Drainage Letter

RCH VALLEY

875 Valley Street,
Colorado Springs, Colorado

July 19th, 2024

SHEET:
 C-2

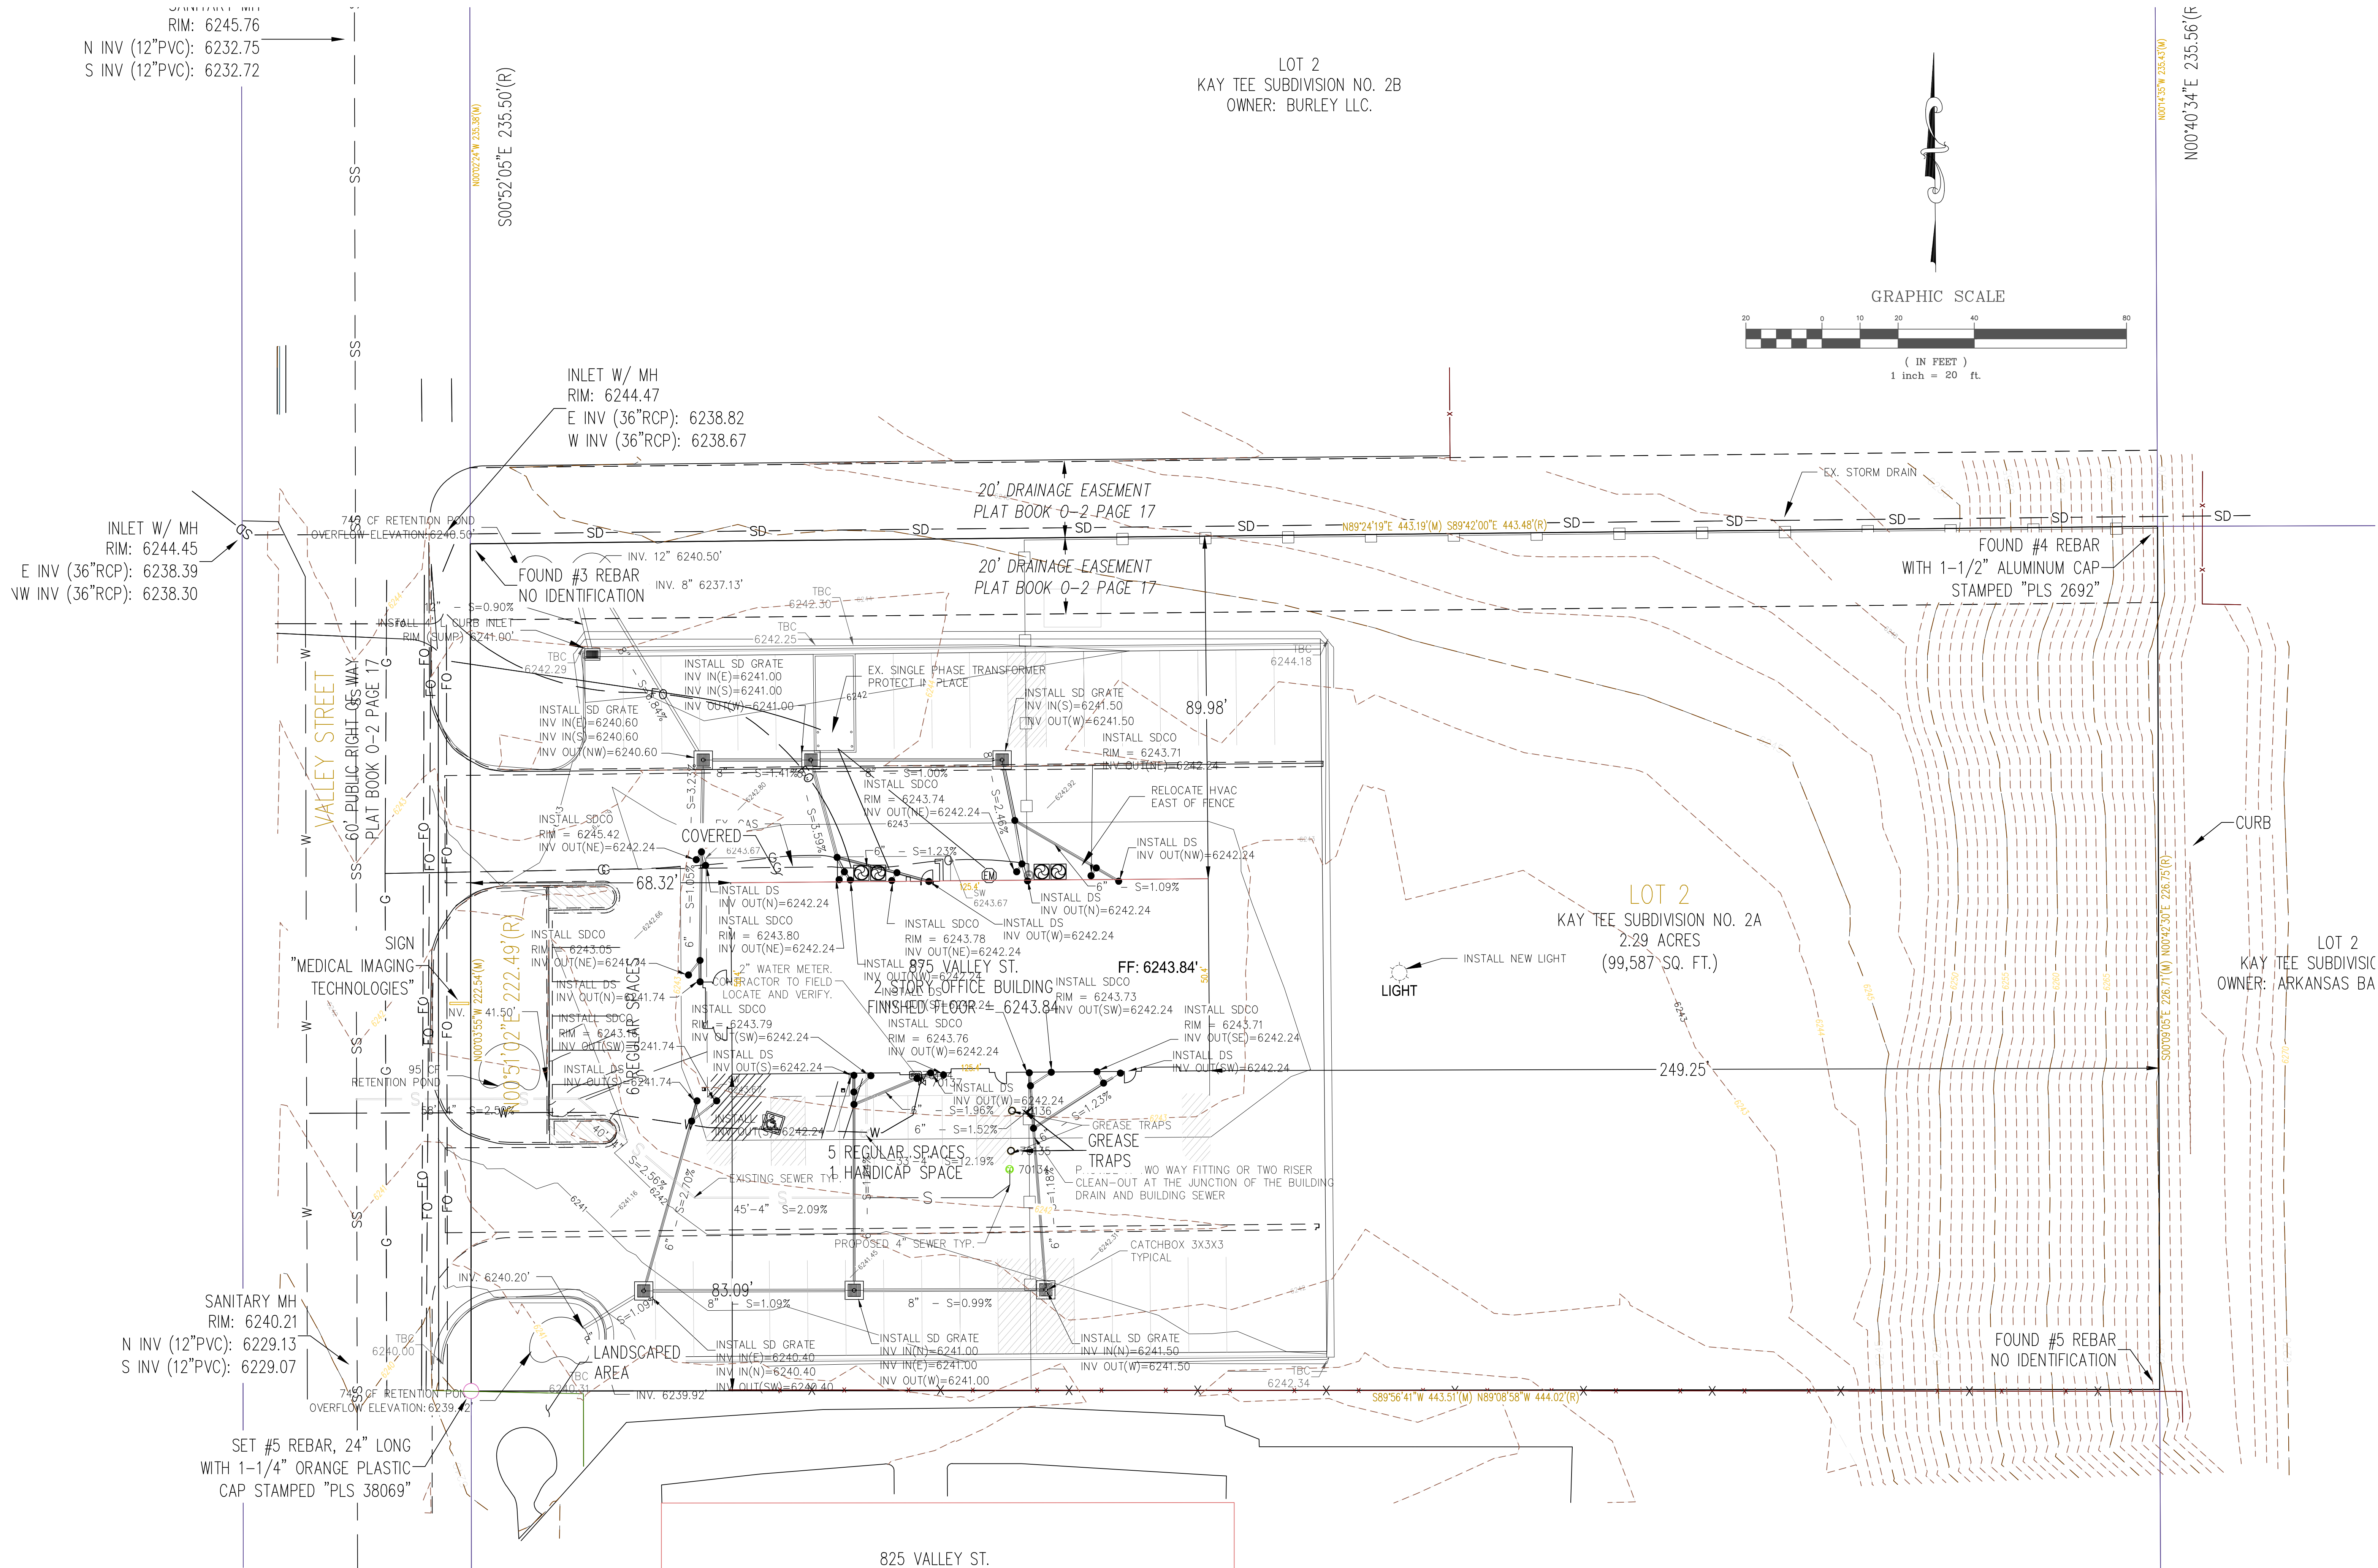
Please see drainage map
Please explain if new private storm drain lines are being routed from the building and into the street inlet.

A work in the right permit will be required for connecting into the street inlet

Please remove these 3 "retention pond" labels and call receiving pervious area only. These wont be retention or detention pond per stds

label as existing or proposed
